From: Simon Davis
Sent: 11 February 2019 17:03
To: 'Charlotte Grant'
Subject: RE: Wilko Site, London Road, Bognor Regis BR/270/18/PL

From: Simon Davis
Sent: 07 February 2019 12:52
To: 'Charlotte Grant'
Subject: RE: Wilko Site, London Road, Bognor Regis BR/270/18/PL

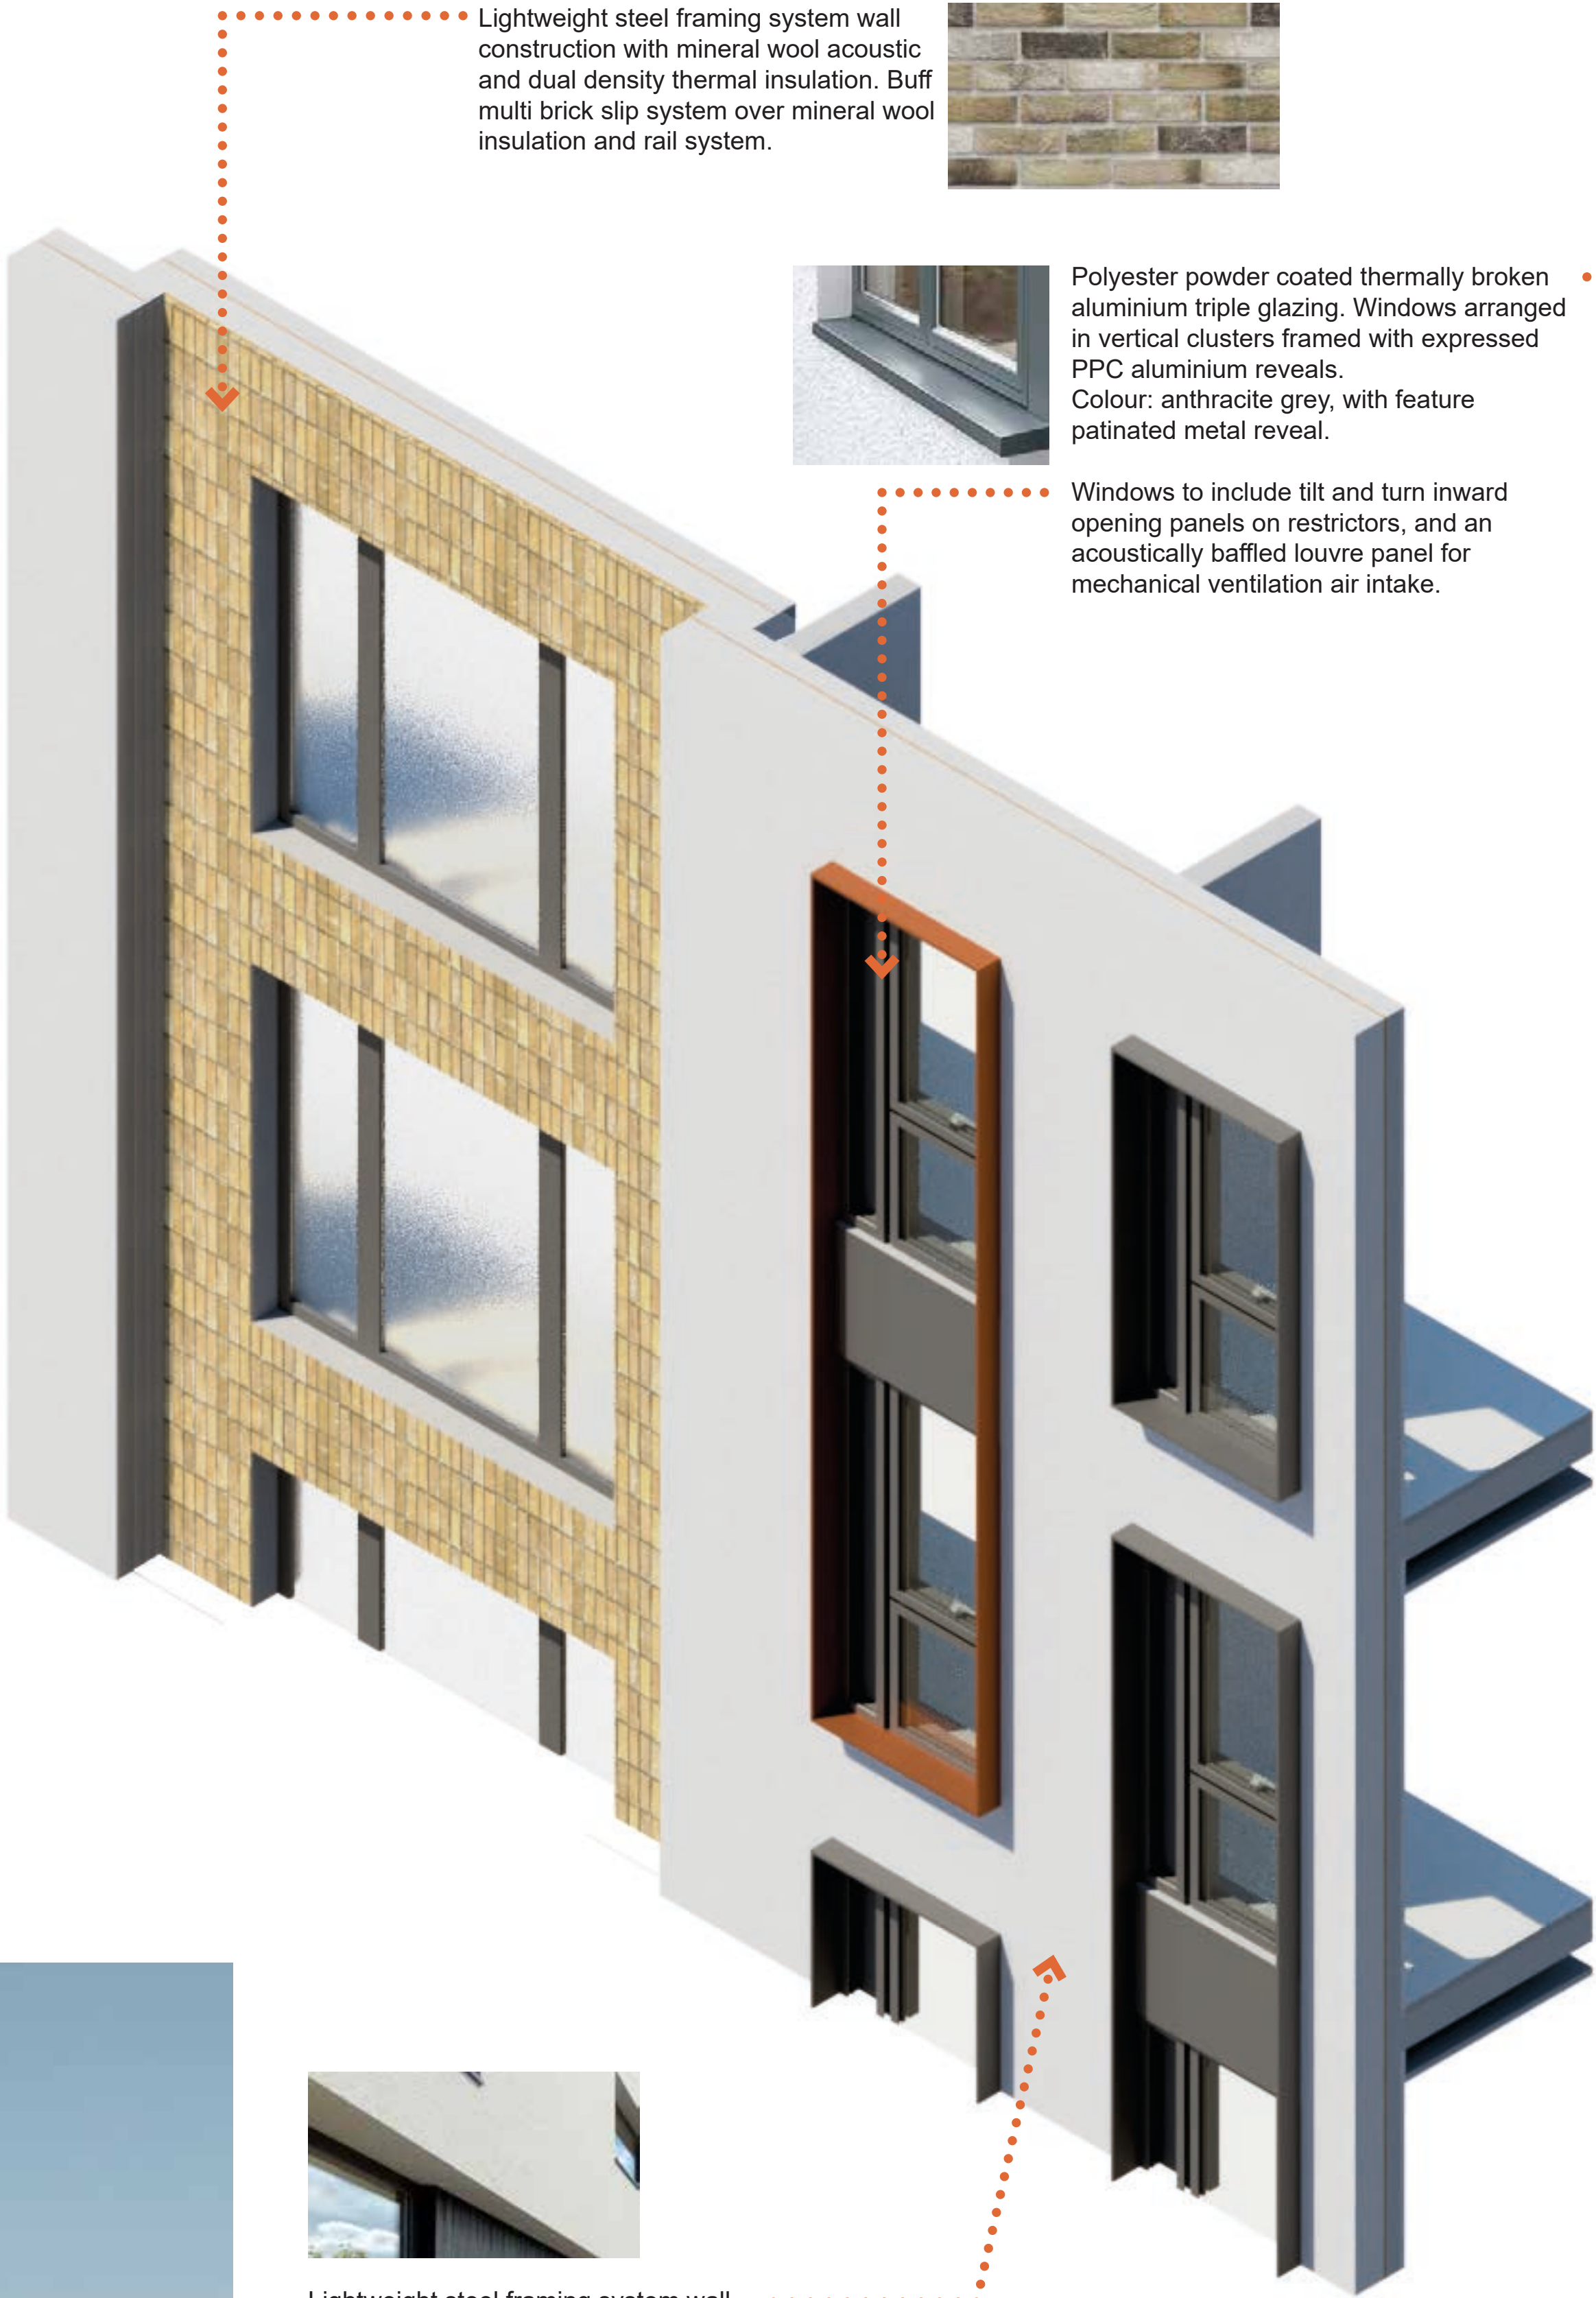
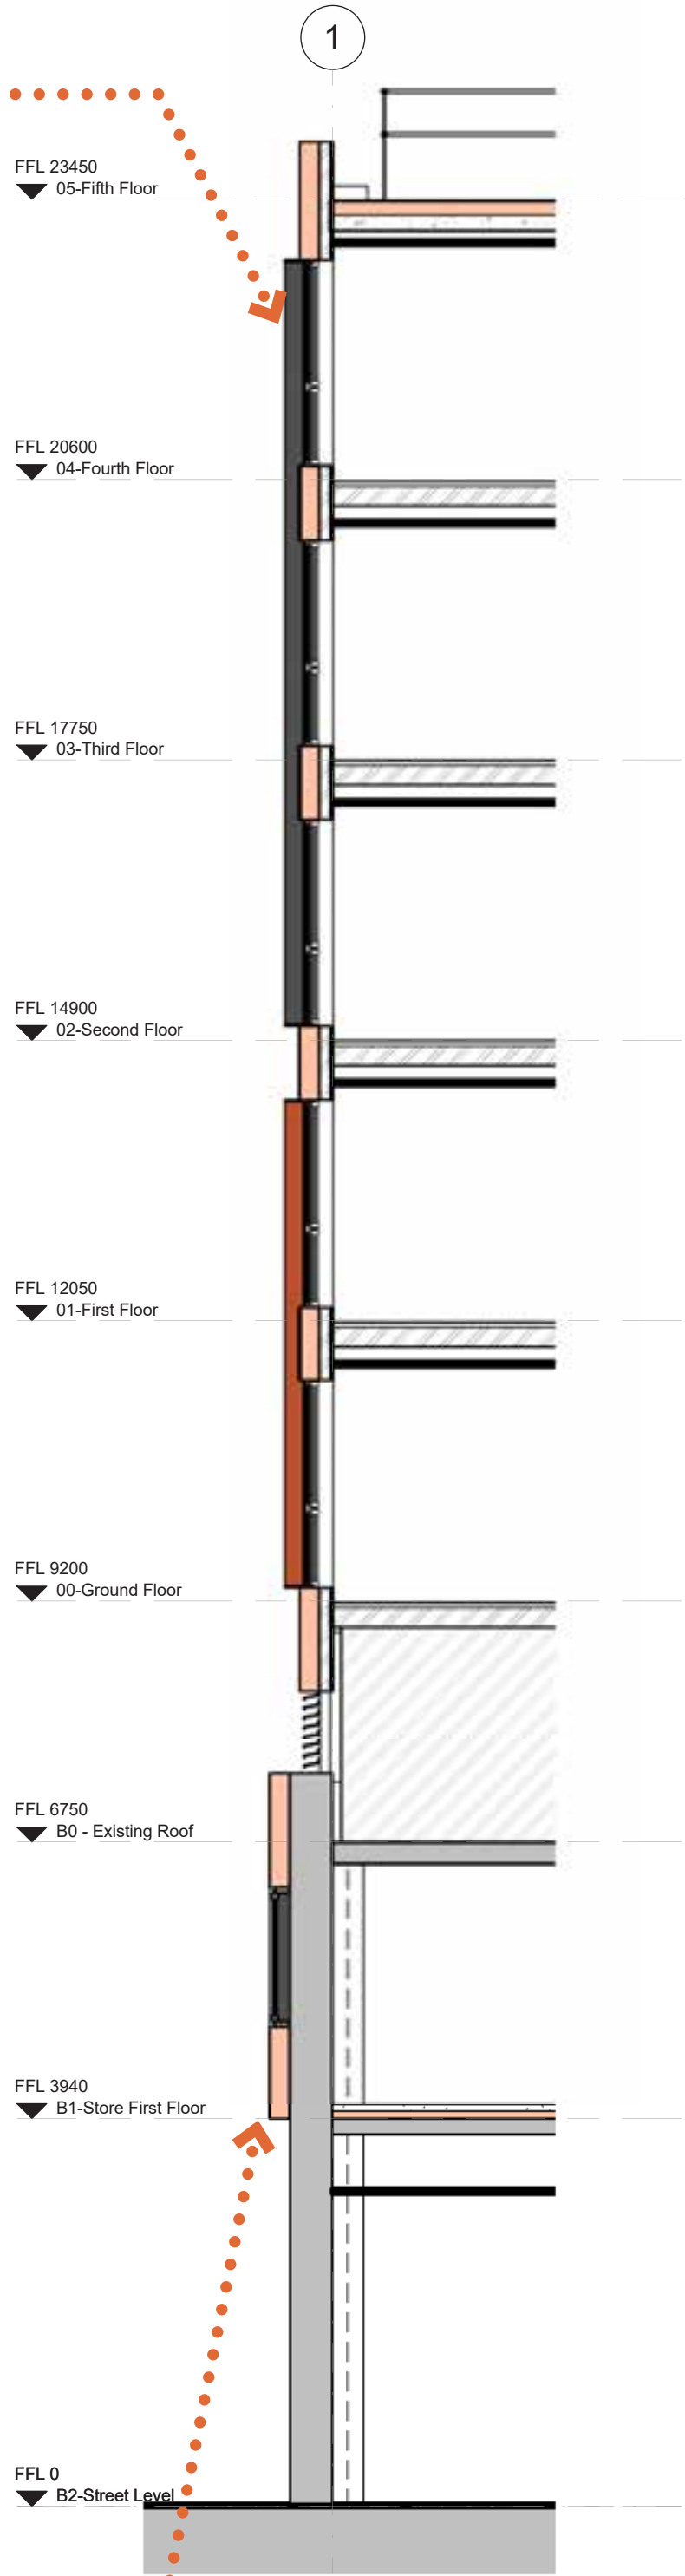
1. It was felt that there is no continuity between the Wilko's Bedford Street elevation and the new building proposals above.
2. It was felt that there is no relief to the starkness of the sheer elevation upwards – options suggested setting the new build away from the Bedford Street edge of the Wilkos building and/or adding in some features within the elevations to add relief – for example some bay style or recessed windows. It was felt that the elevation is very flat compared to Fitzfleet House for example. Note that there were no issues raised with how the London Road elevations are treated.
